Online Comment

Application H16-0110-17
Location 1 Woolram Wygate Spalding PE11 1NX
Proposal Change of use from office accommodation to house of multiple occupation (HMO)

Date Submitted 23-02-17
For/Against Objections

BLOCK PLAN 1:200

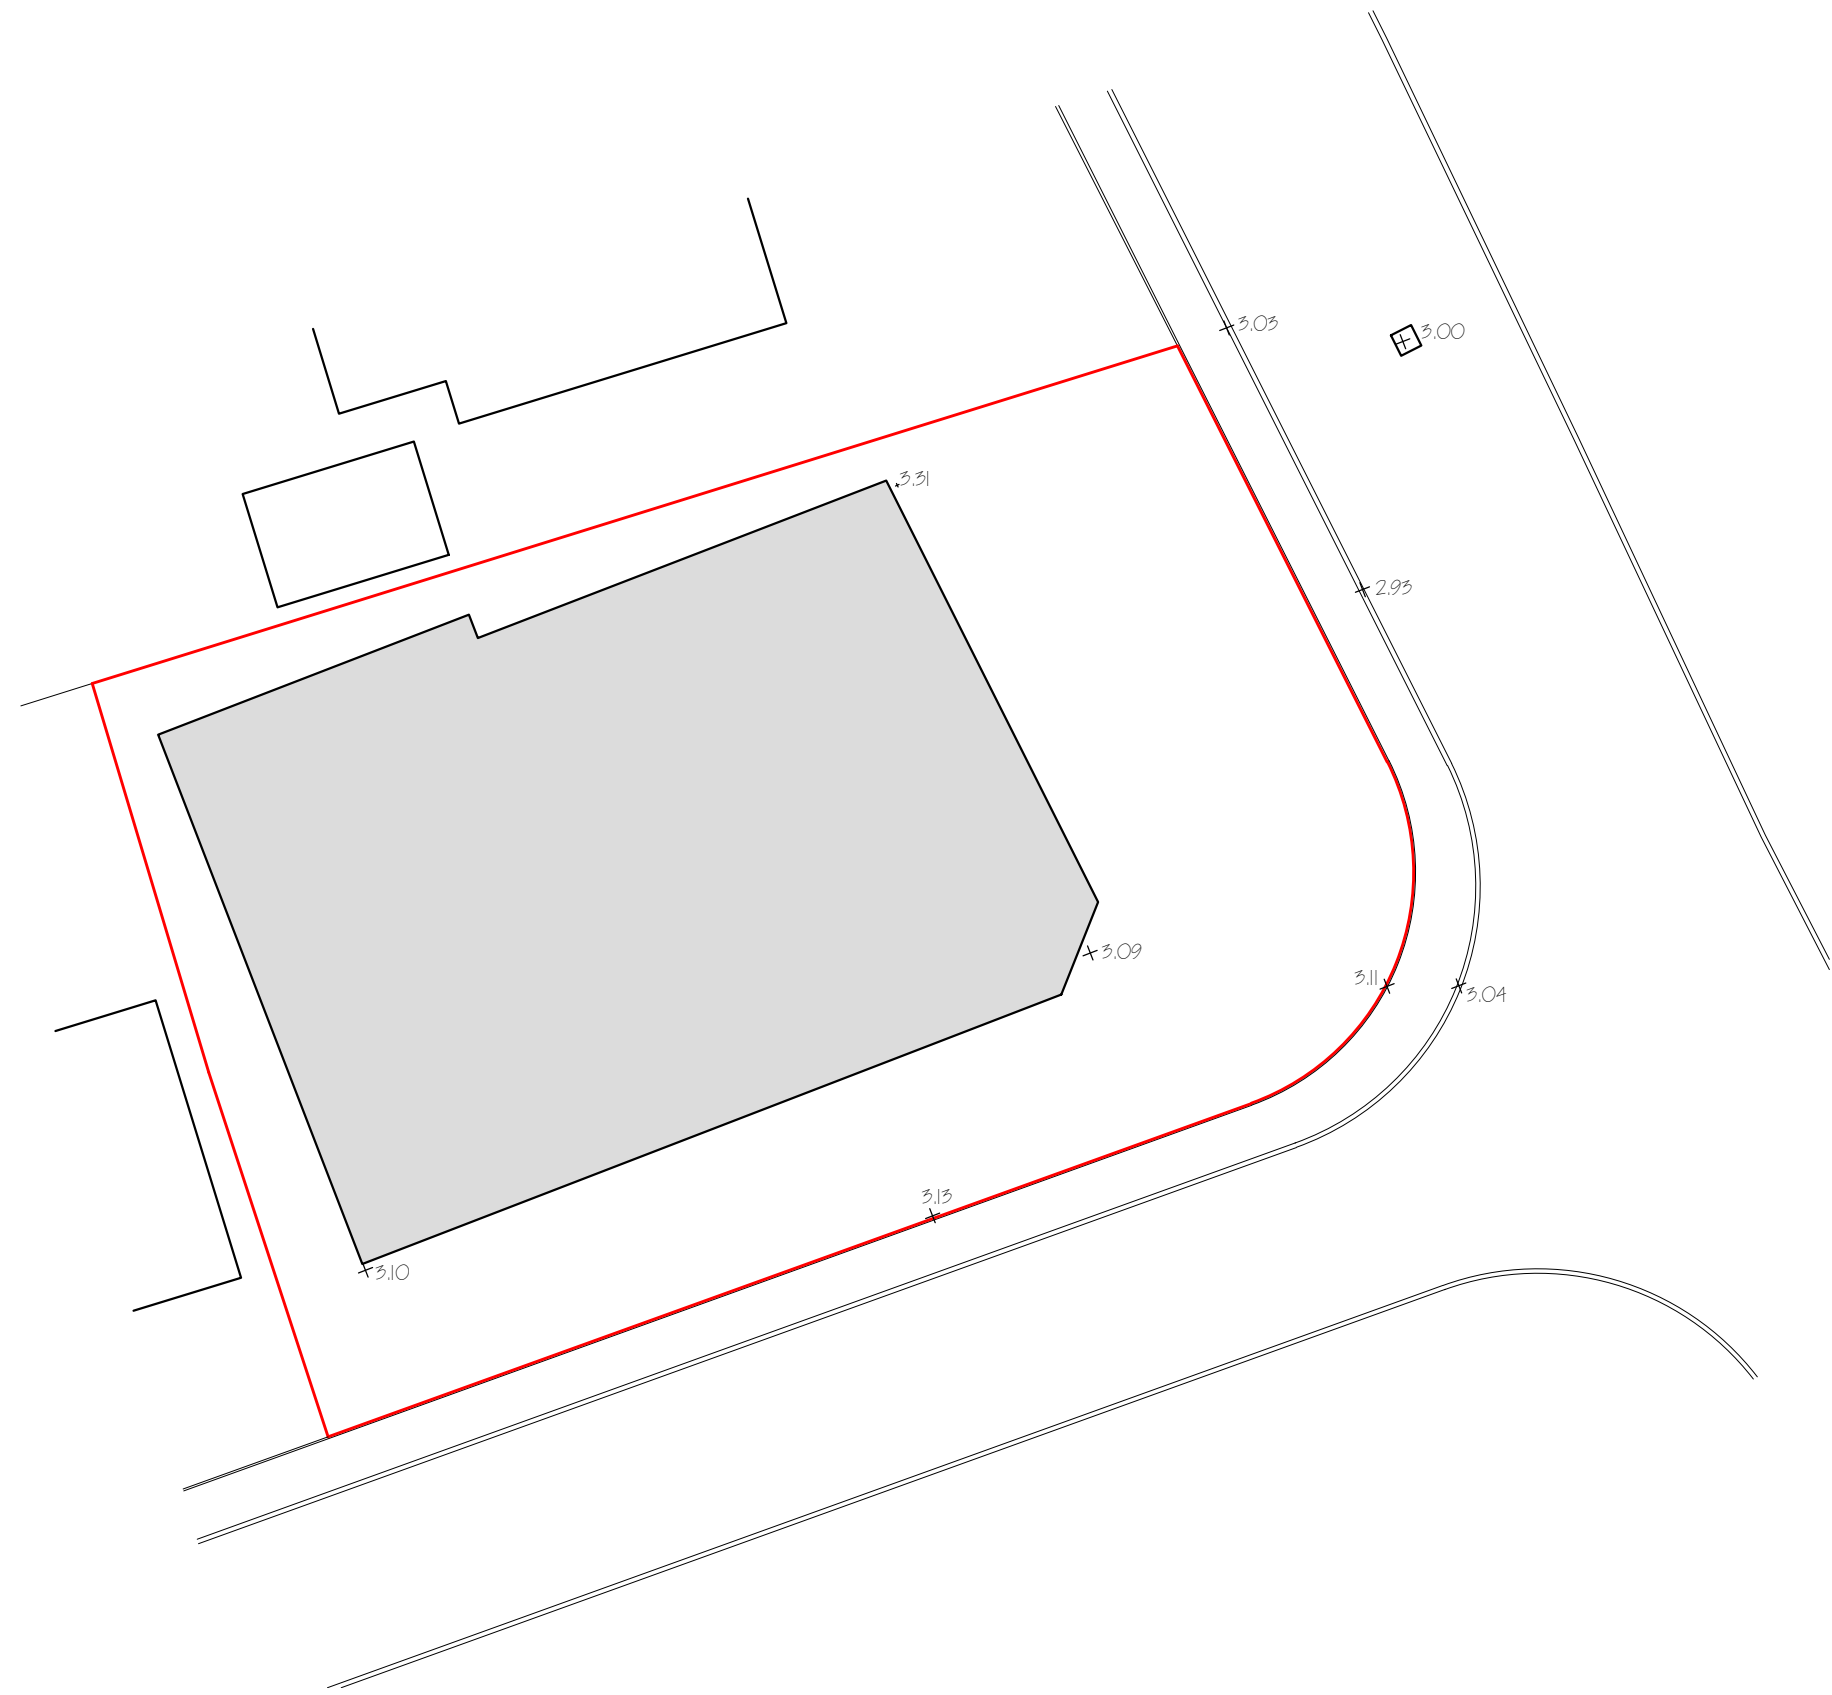
The application site is within convenient cycling distance of work-places, leisure facilities, shops and the town centre. Some of the prospective residents of this development are likely to want to use cycles, and yet the application makes no provision for cycles to be stored securely and protected from adverse weather. So we object to the application unless it is amended to include satisfactory arrangements for storing cycles.
